**Application by INGR Solar (Little Crow) Limited for Little Crow Solar Park**  
**The Examining Authority's written questions and requests for information (ExQ2)**  
**Published on Friday 11 June 2021**

**ExQ2: 11 June 2021**

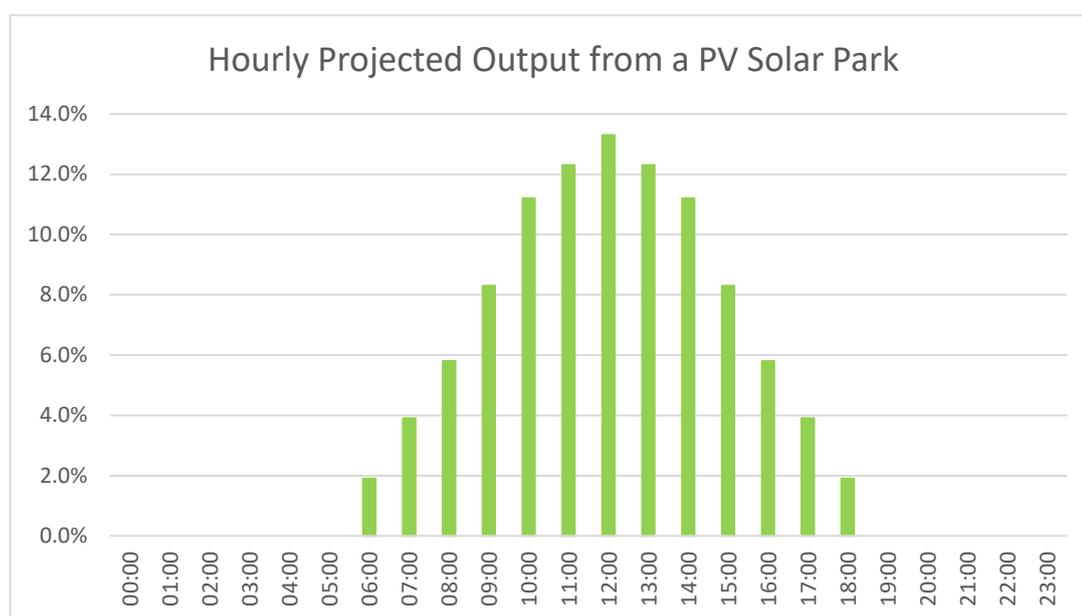
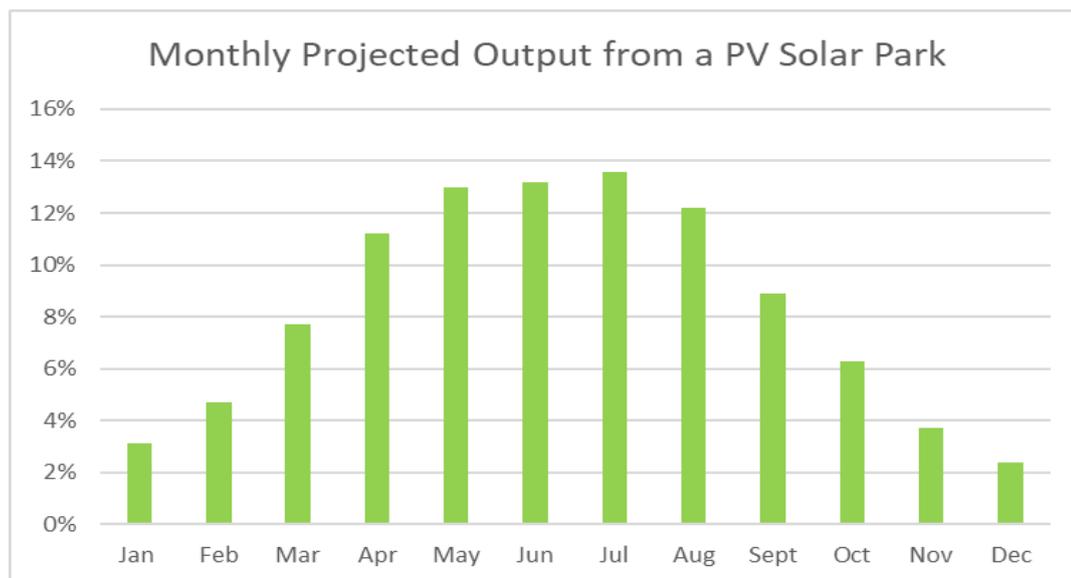
2.1.6	The Applicant	<p>Following on from the predicted hourly and monthly power generating outputs shown in Figures 6 and 7 in section 6 of the Technical Guide [REP1-011], for the Proposed Development please provide hourly and monthly predictions in an appropriate generating unit for electricity for:</p> <p>a) The generation of electricity by the proposed solar array; and</p> <p>b) The export of electricity to the grid from the Proposed Development, ie directly from the solar array or via the solar array in combination with the battery storage system or the battery storage system alone.</p>
